From: Martyn White
Sent: 18 January 2019 12:24
To: Planning.Responses
Cc: Zac Denton
Subject: AB/135/18/HH & AB/136/18/L

AB/135/18/HH & AB/136/18/L

The application relates to an existing sun room which it is proposed to replace on a very similar basis. The sun room is located within the rear garden area of the property, and is attached to a single storey building. This building is located within the curtilage of a listed building, and is therefore curtilage listed. It is also located within the Arundel Conservation area.

PROPOSED PLAN of ELEVENTH
OF CANTONMENT

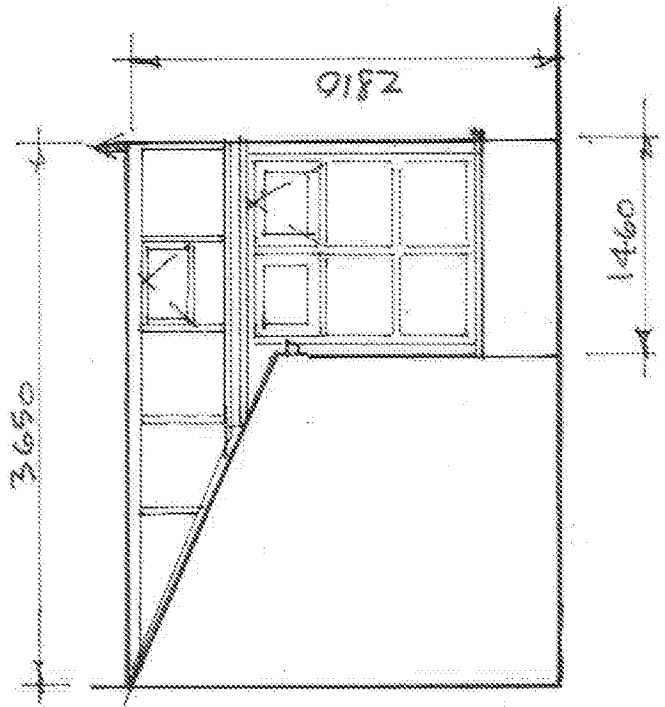
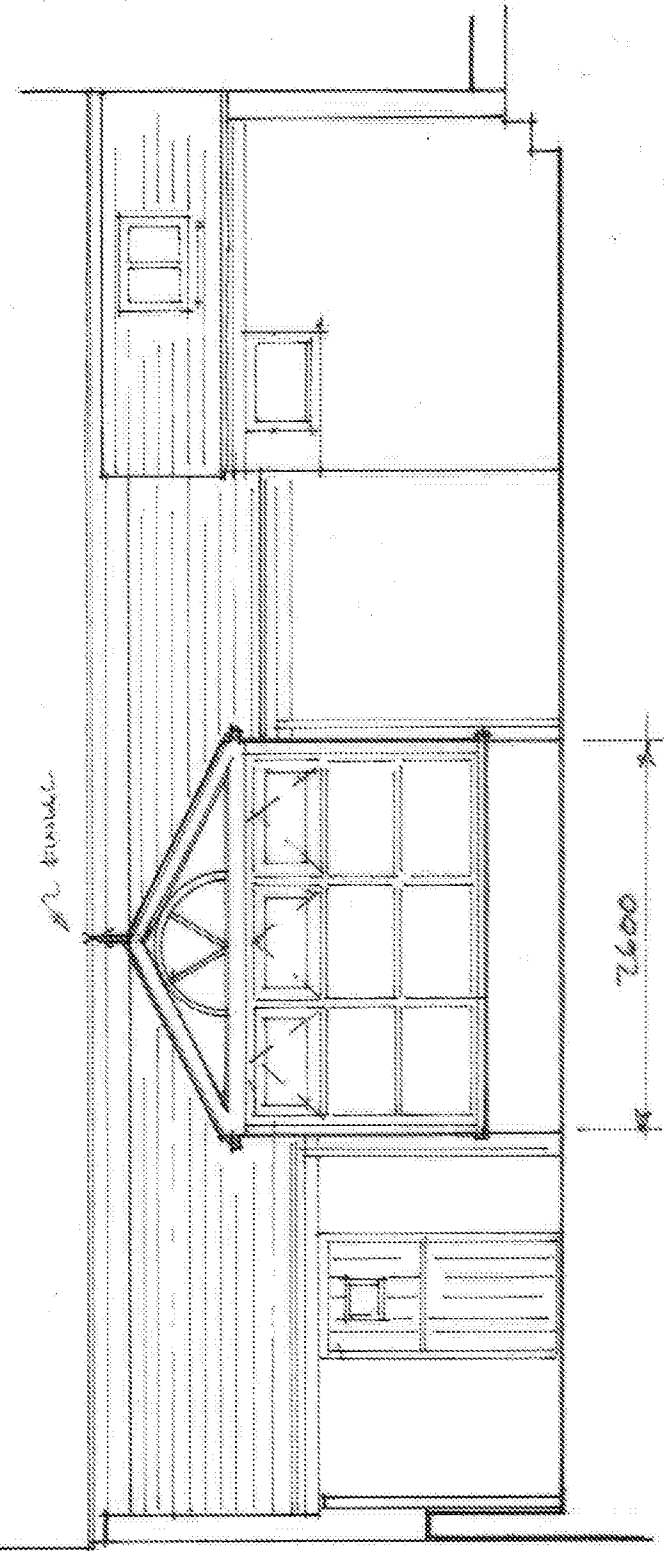
The single storey building is simple in character and constructed using traditional materials. It plays a subservient role to the main dwelling, and the proposal should ensure that this relationship continues. Essentially, as the proposal will replace an almost identical structure, there can be no concerns. However, the success of such a scheme will then depend upon the quality of the materials used and the design of the wooden structure/windows. Overall, the design is acceptable, although it would be preferred if the French doors replicated the existing design, such as the inclusion of glazing bars. Further, it is not clear if the units will be single or double glazed?

If minded to approve, you may wish to condition details of the joinery
